Comments for Planning Application CA/20/02636

Application Number: CA/20/02636

Address: All Saints Church Church Street Whitstable Kent CT5 1PG

Proposal: Installation of gate to church car park.

GATE

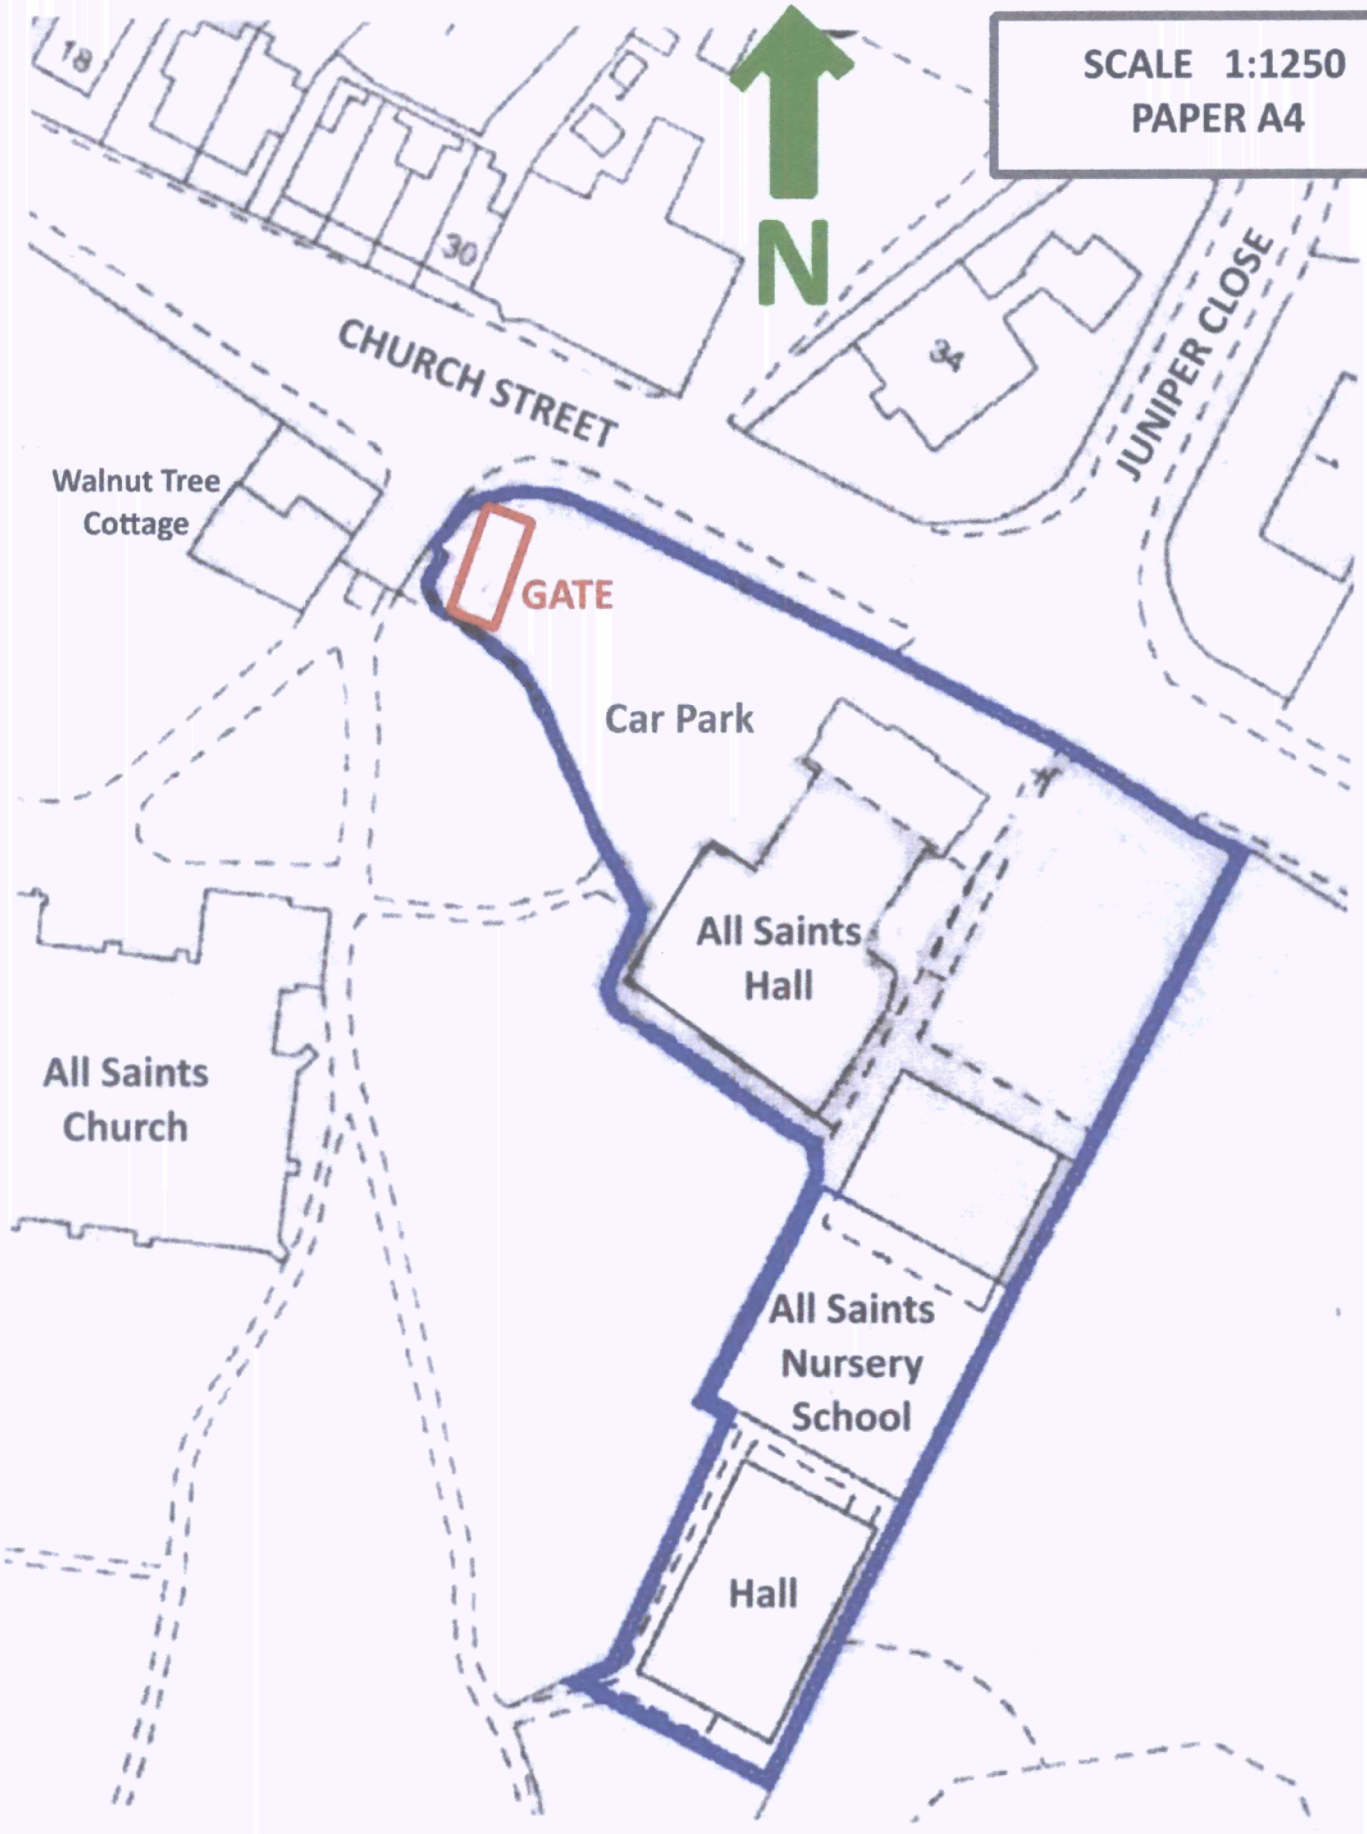
Comment: Visitors to the churchyard may create a traffic tailback when accessing the car park, opening and closing gates, which would block an already narrow and busy road and a bus stop. This would also create a pollution issue with waiting cars.
